Ellicott Town Center Filing 2
Traffic Impact Study
PCD File Nos. CS192 & SF1910
(LSC #194060)
March 31, 2020

RE: Ellicott Town Center Rezone
Filing Nos. 2 and 3
Traffic Impact Study
El Paso County, Colorado
LSC #194060
PCD File Nos. CS192 and SF1910

## Short-Term Baseline\* + Site-Generated (Filings 2 + 3) Traffic, Lane Geometry, and Traffic Control

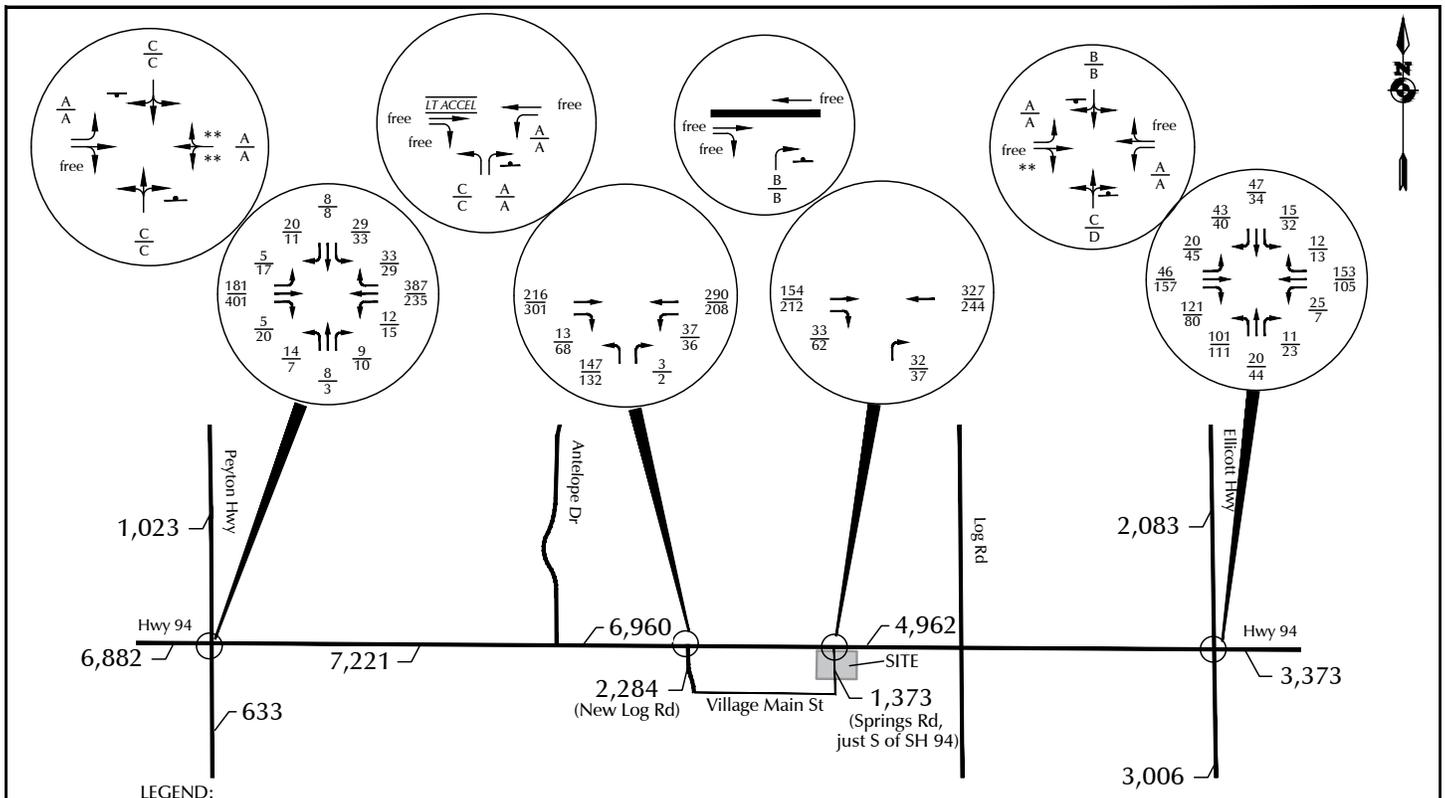
It appears that this should be figure 8, figure 8 has filing 2+3 site generated traffic.

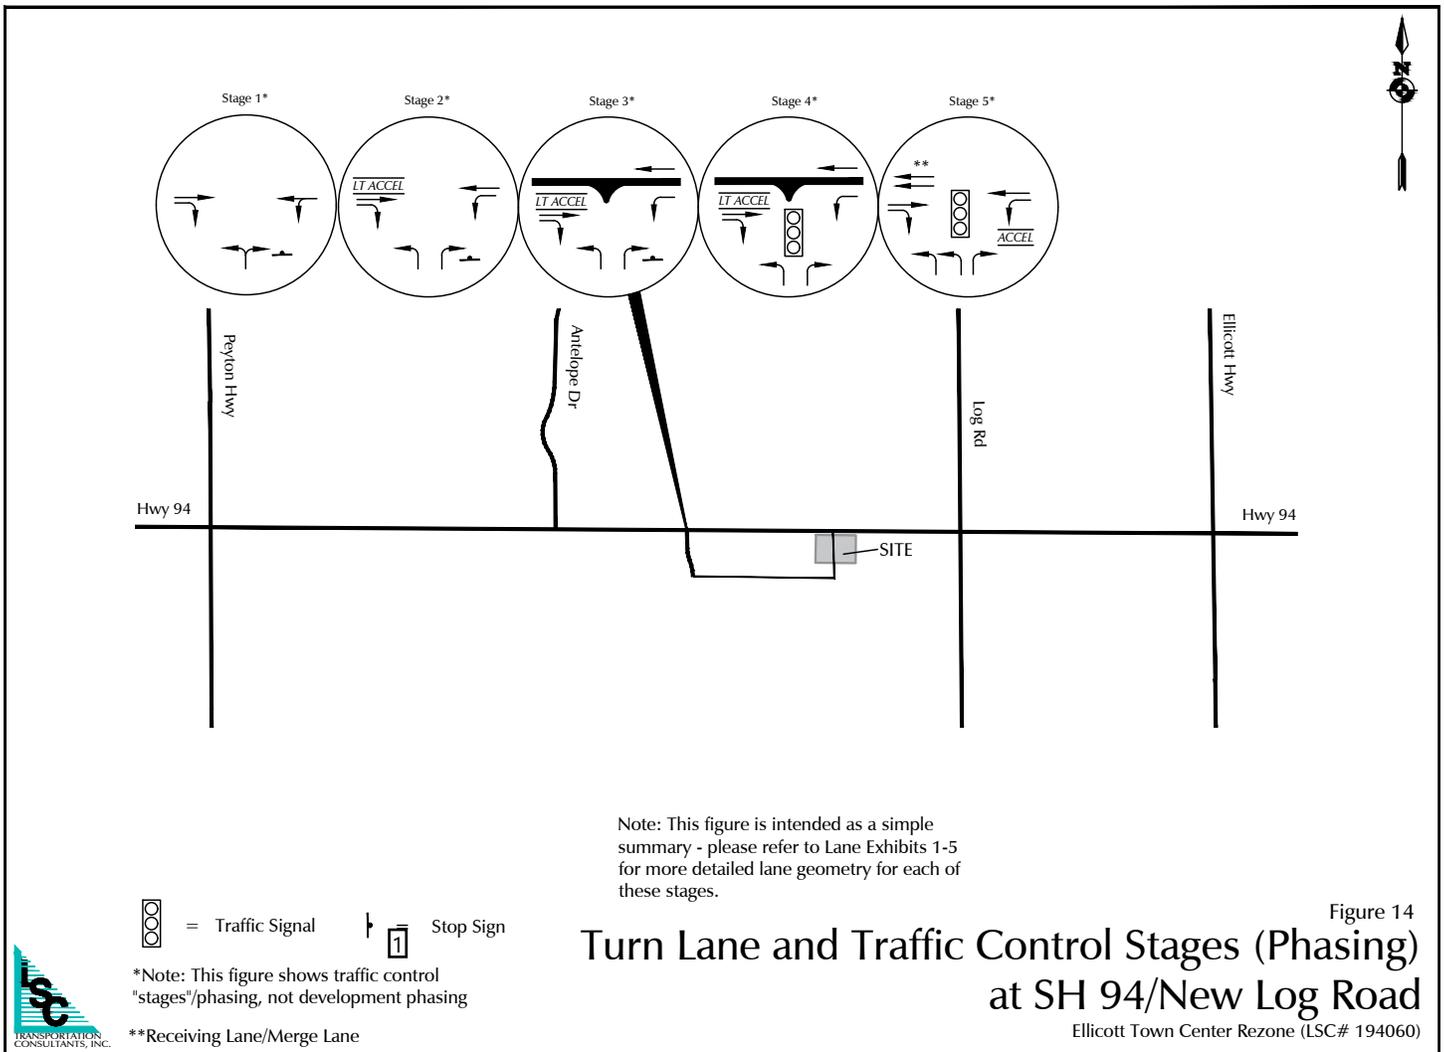
Figure 8 is the entire rezone
